CITY OF ALBUQUERQUE

November 29, 2021

Re: US Eagle Credit Union - Academy
5420 Academy Road NE
Traffic Circulation Layout
Engineer's Stamp 11-23-2021 (E18-D046)

Issue Date: 09/03/2021
Architect: B. Bily
Drawn By: PS
Checked By: MS
Project Number: 29643-0003
Title: **SITE PLAN**
Sheet No. **C-100**

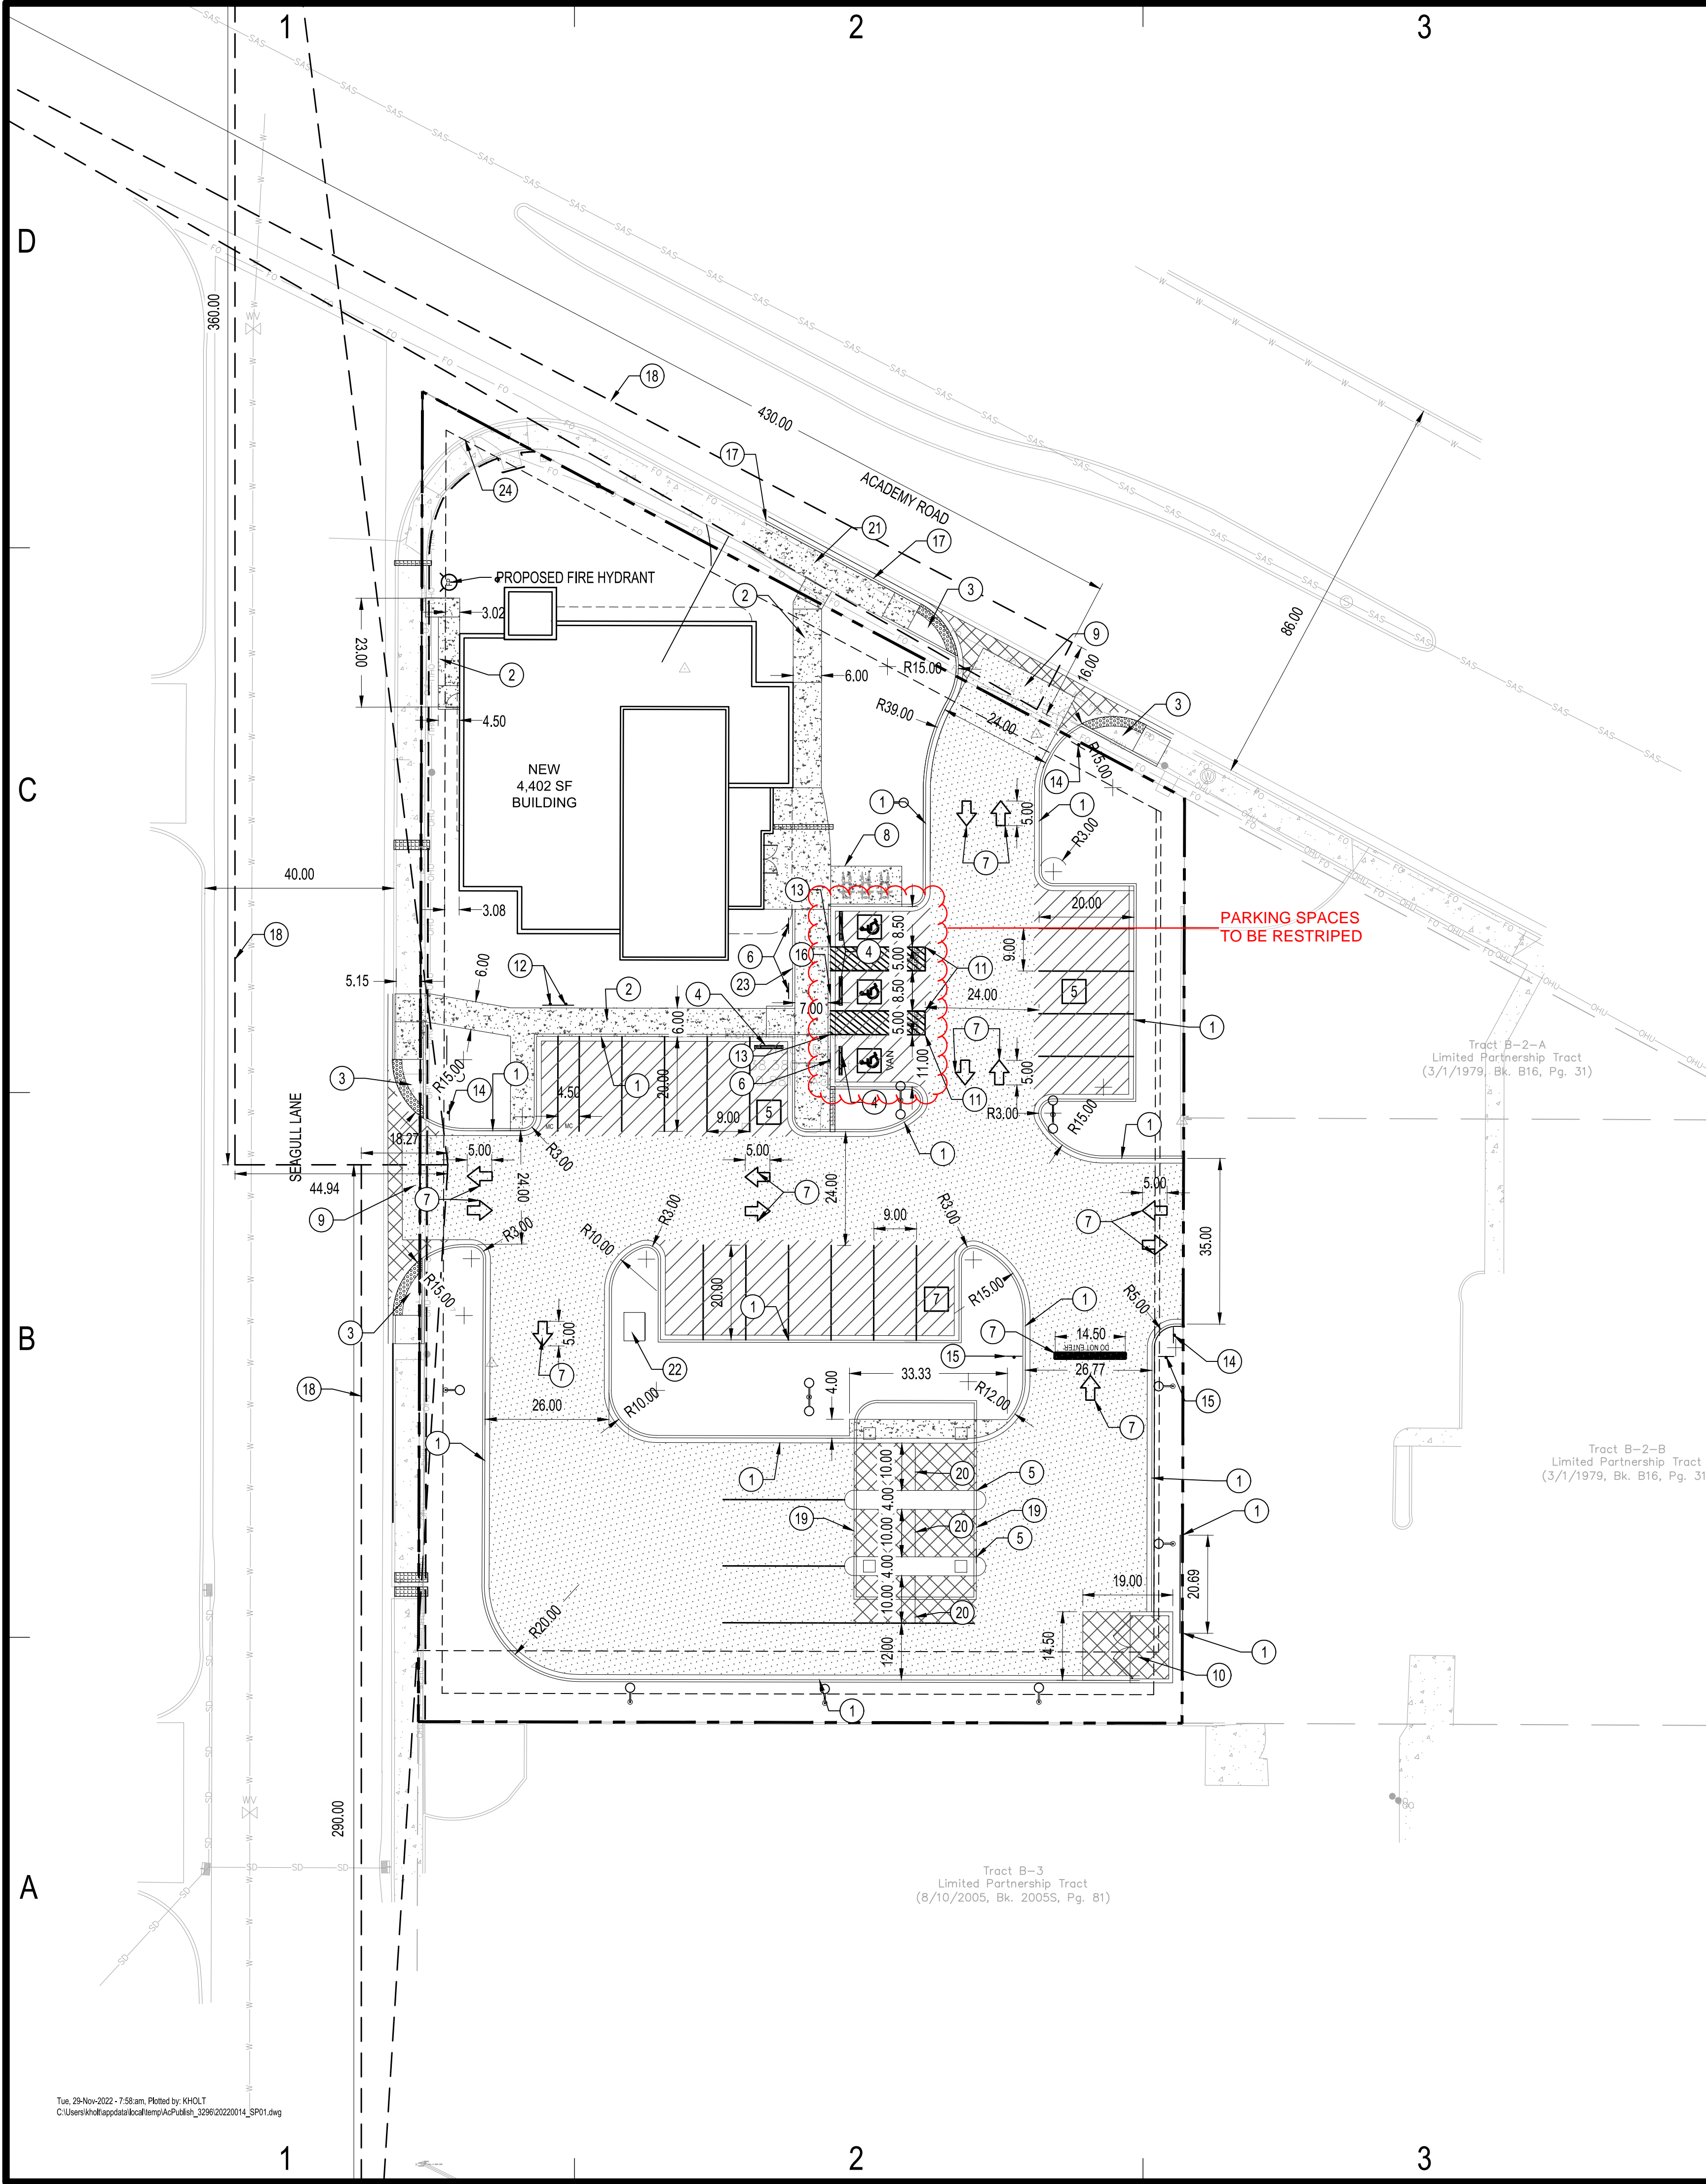
- Due to sight distance concerns and to construct sufficient curb ramps, right-of-way dedication is required to add curves to corners of properties at intersections if they are not already developed. See Table 23.3 of the DPM.
- Or provide a sidewalk easement at this corner.
- Existing Ramp: The ramp will need to be current/updated ADA and if it isn't then you will need to provide ramp and detail per COA std dwg 2441. The existing ADA ramp is not ADA will need to be replaced.

2. **Keyed Note 7:** You will need to provide details for proposed pavement markings. The size and dimensions will need to be provided. Prior comment not addressed.

3. The ADA accessible spaces must include an access aisle. Van accessible aisles **should be 8ft wide**; all others should be 5ft wide. **You show two 5ft access aisles but one needs to be 8ft wide Van accessible aisle.**

5. **Keyed Note 18:** Academy/Seagull The clear sight triangles/line will need to dimensioned. **This is a prior comment not addressed.**

6. **Shared Site access:** driveways that straddle property lines, or are entirely on one property but are to be used by another property, shall have an access easement. Please include a copy of your shared access agreement with the adjacent property owner. **This is concerning the proposed 35 ft wide access to Tract B-2-B.**
